From: [REDACTED]
Sent: 28 March 2019 12:13
To: Andrew Wood
Subject: Fwd: FG/220/18

I am writing this in relation to the late amendment to the plans submitted by the applicants in the planning application FG/220/18 - land at Elm Lodge, Tamarisk Way, Ferring.

Drawing Title **PROPOSED POND ACCESS
PLAN**

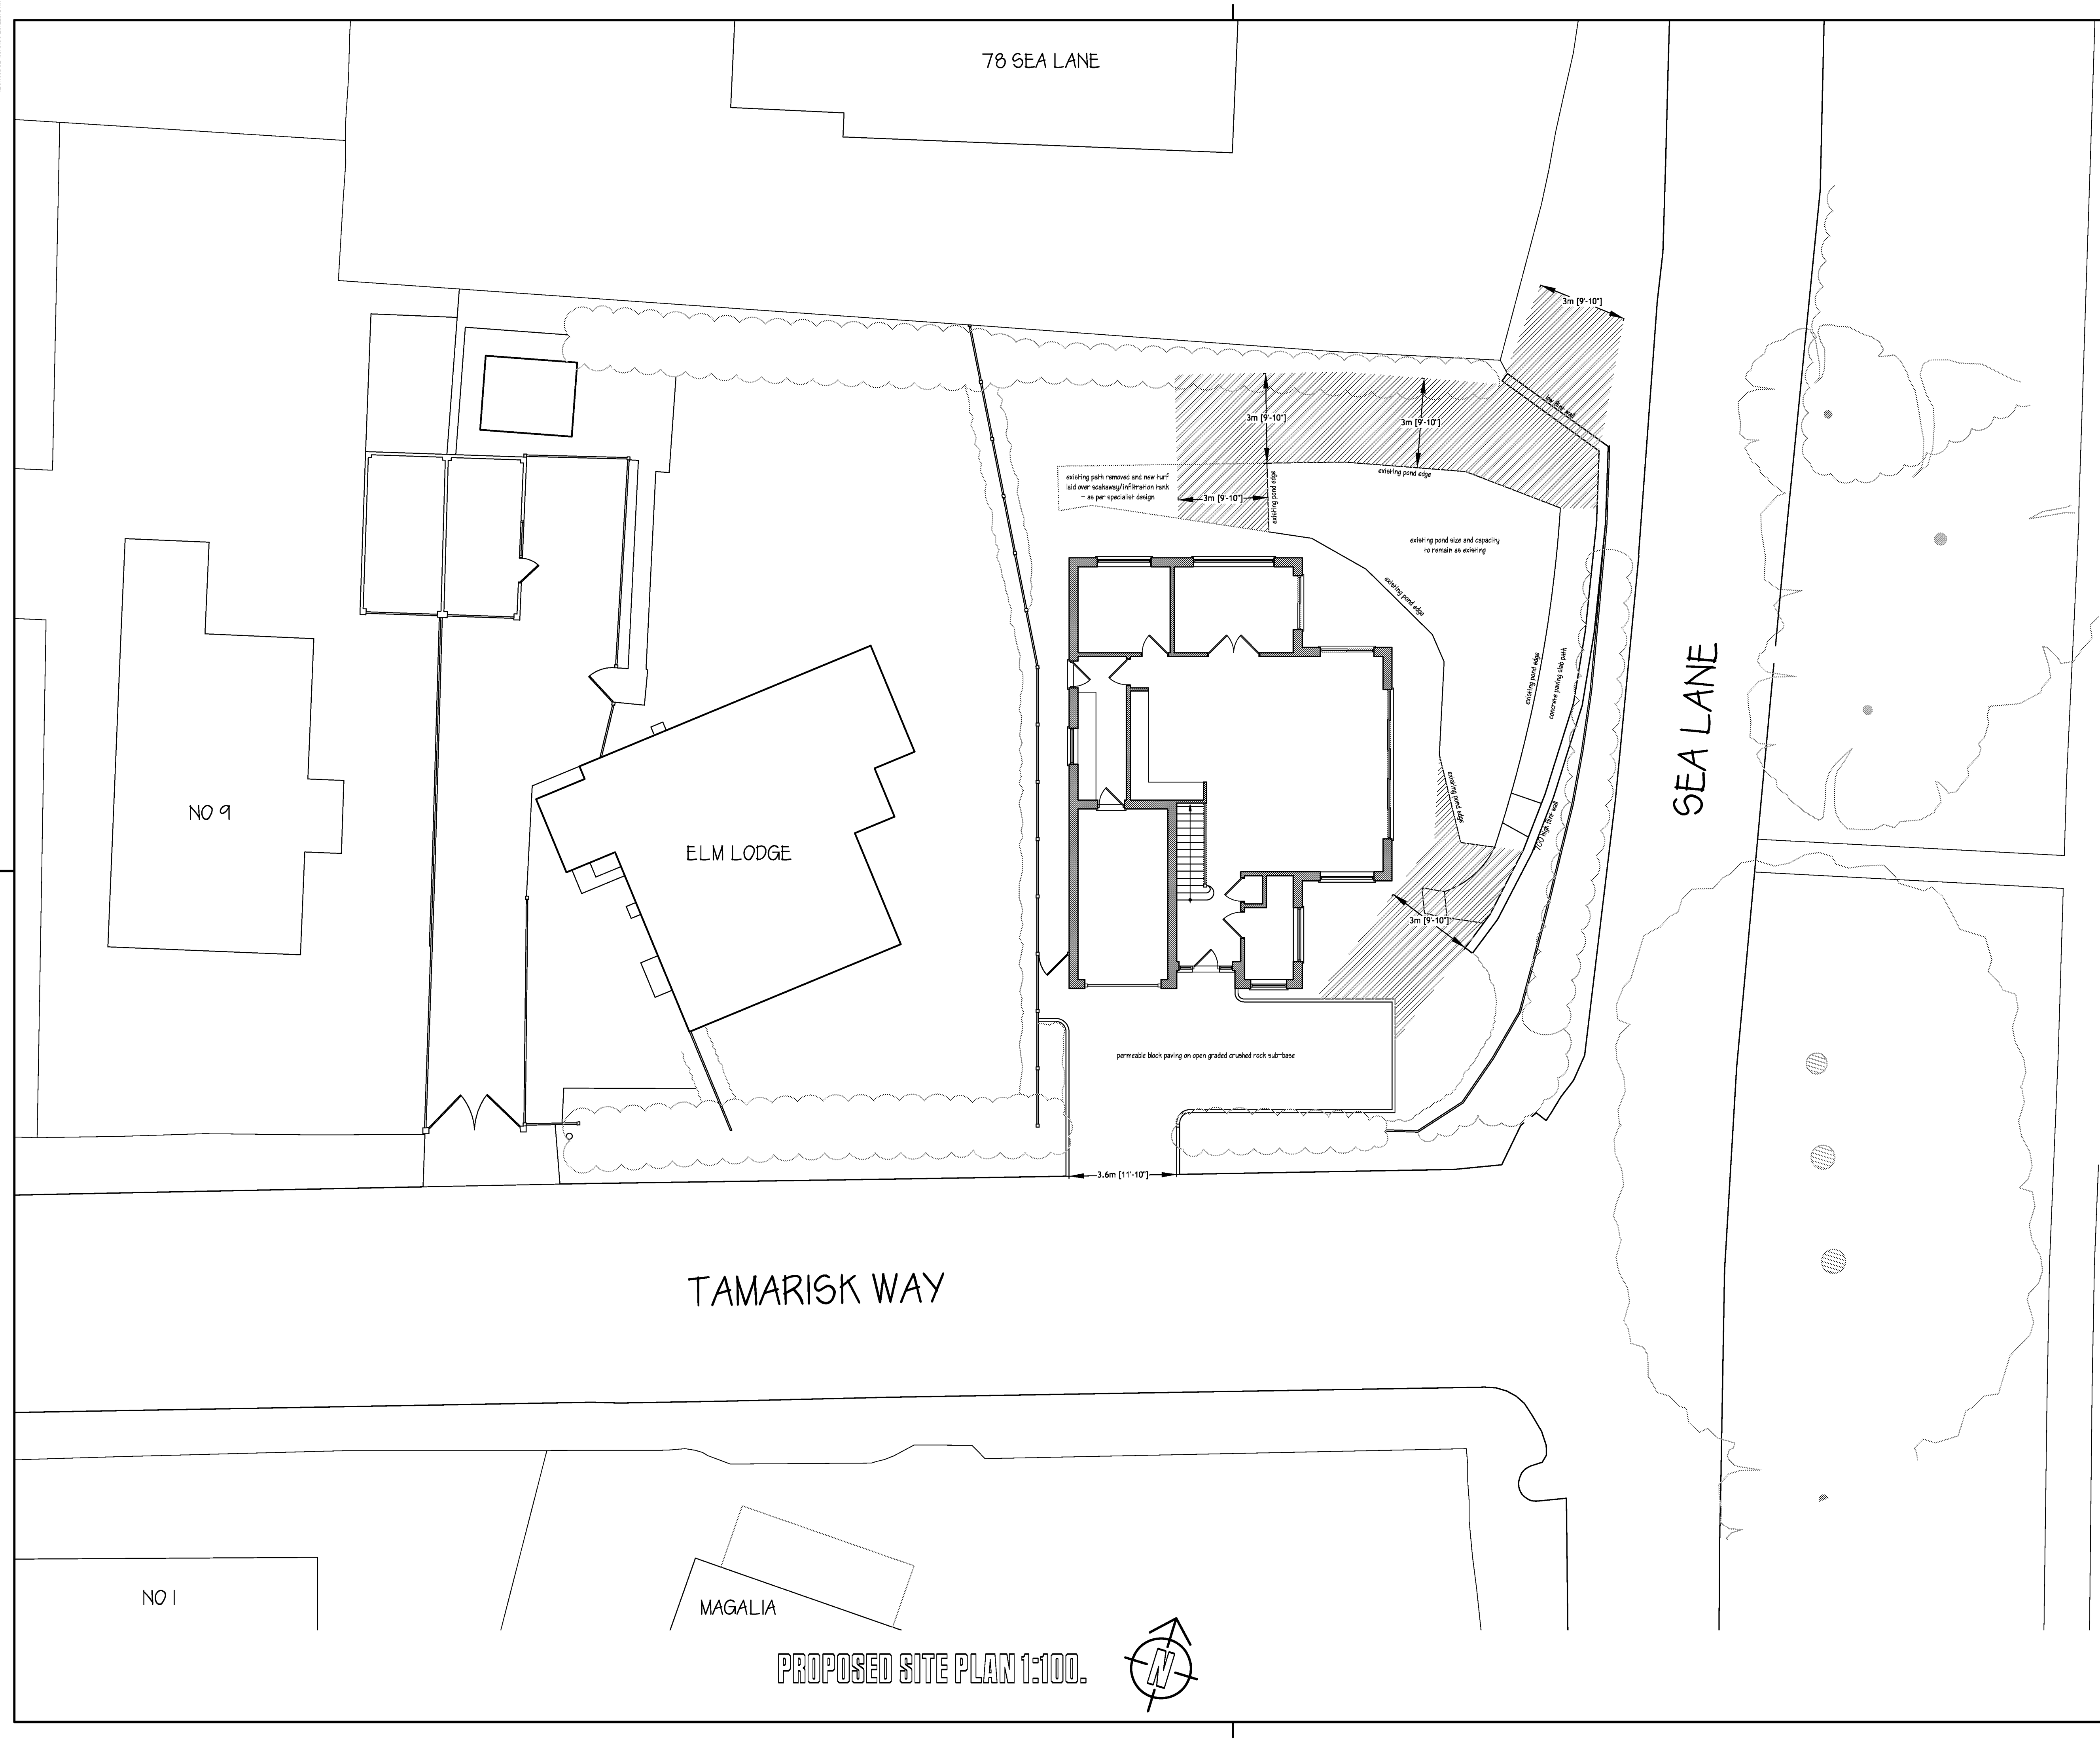
This appears to be an attempt simply to circumvent the very proper and sound objection put forward by the Arun District Council drainage engineers, and the real concerns of the local residents who actually live here and have done in most cases for many years.

There is absolutely no doubt that surface flooding is an issue in this area (evidenced by the photographs submitted by residents) and also there is an issue of a high ground water table here especially after periods of heavy rain (evidenced practically when digging into the soil and also by the number of occasions that BT have to replace cabling in the Sea Lane area after water ingress into their cable system). No amount of fiddling around with the proposed plans on the applicant's computer will and can change this situation. Drainage is our number one concern with these plans and it still appears that the intention is to site a soakaway and its associated cage system exactly in the area of the existing drainage pipe system that leads towards my property. This makes no sense as it is very likely to adversely affect our village drainage system. I do hope that nobody is drawn into a false sense of security this year as we have experienced a very dry winter when water levels are currently much lower than usual. We must expect and be able to deal with future extremes of weather due to climate change.

Drawing Title
PROPOSED LOCAL AREA
PLAN

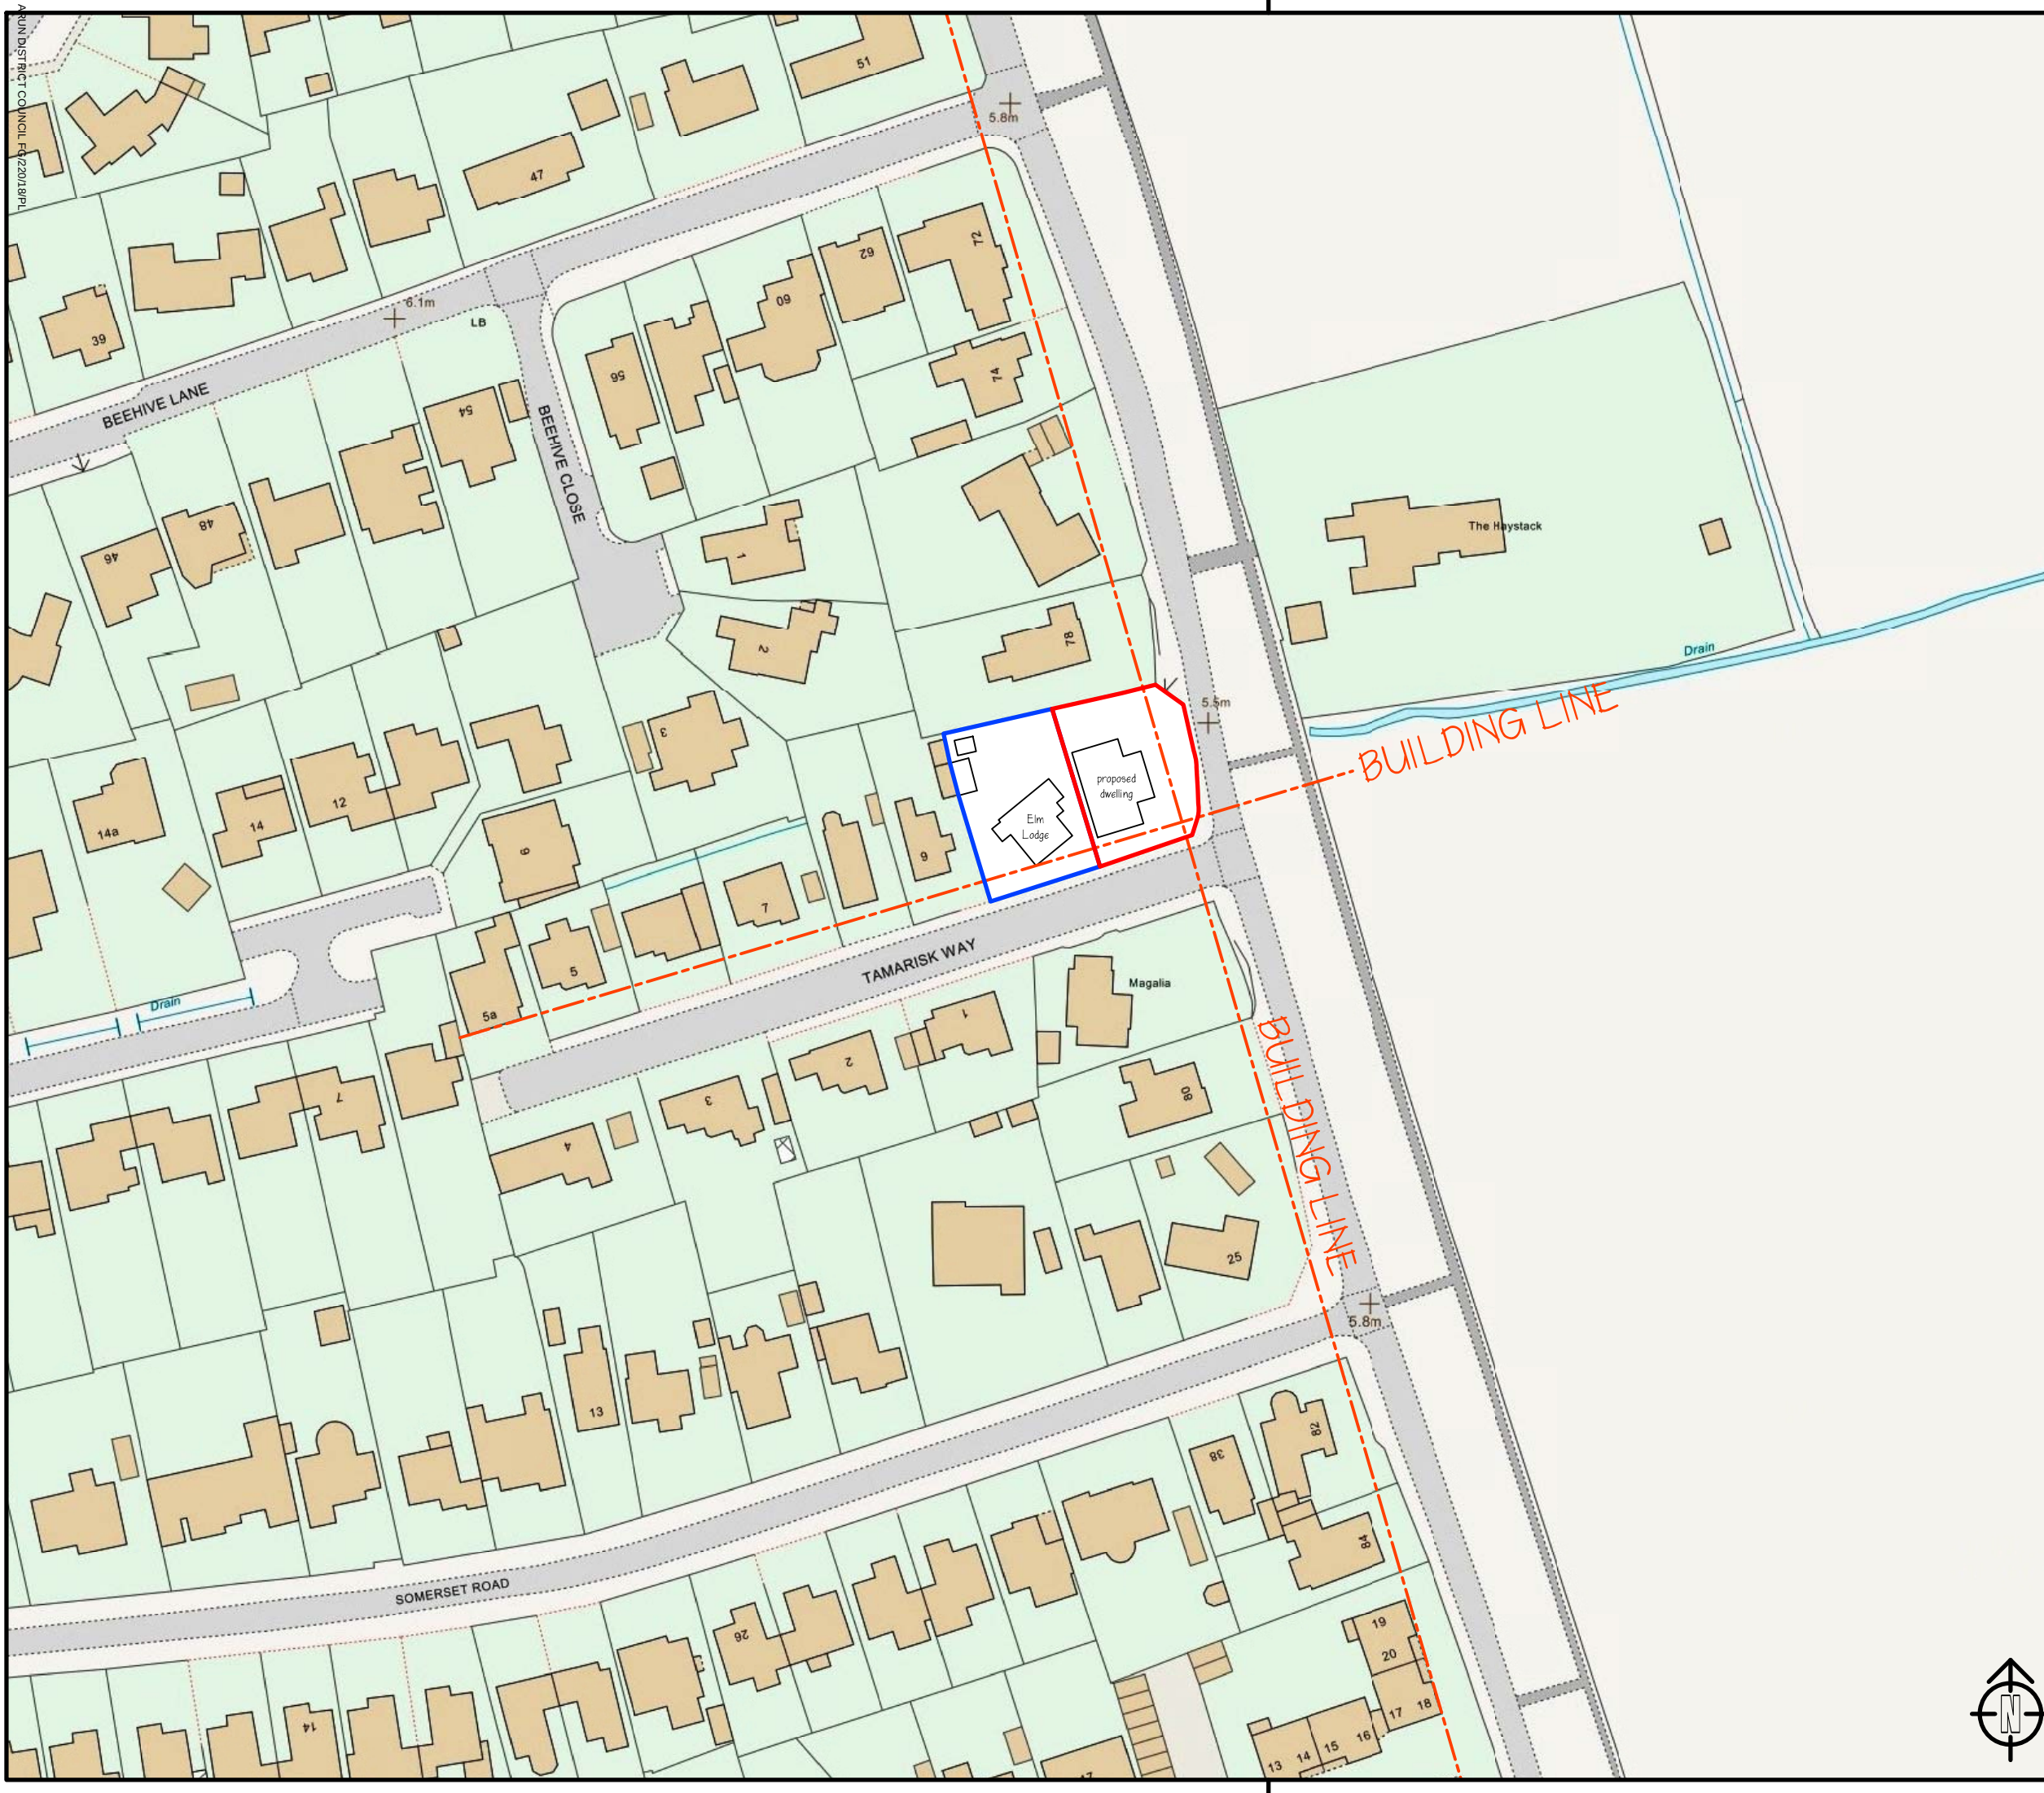
In addition, the updated proposed plan appears to move any new property even closer to the existing Elm Lodge in order to move it away from the pond. The consequence of this would be to make the situation even more cramped and out of character to the local area by squeezing the two properties closer together. Surely it must be realised that there is simply insufficient room on this site to shoe horn in another property without compromising the pond and the effective drainage system.
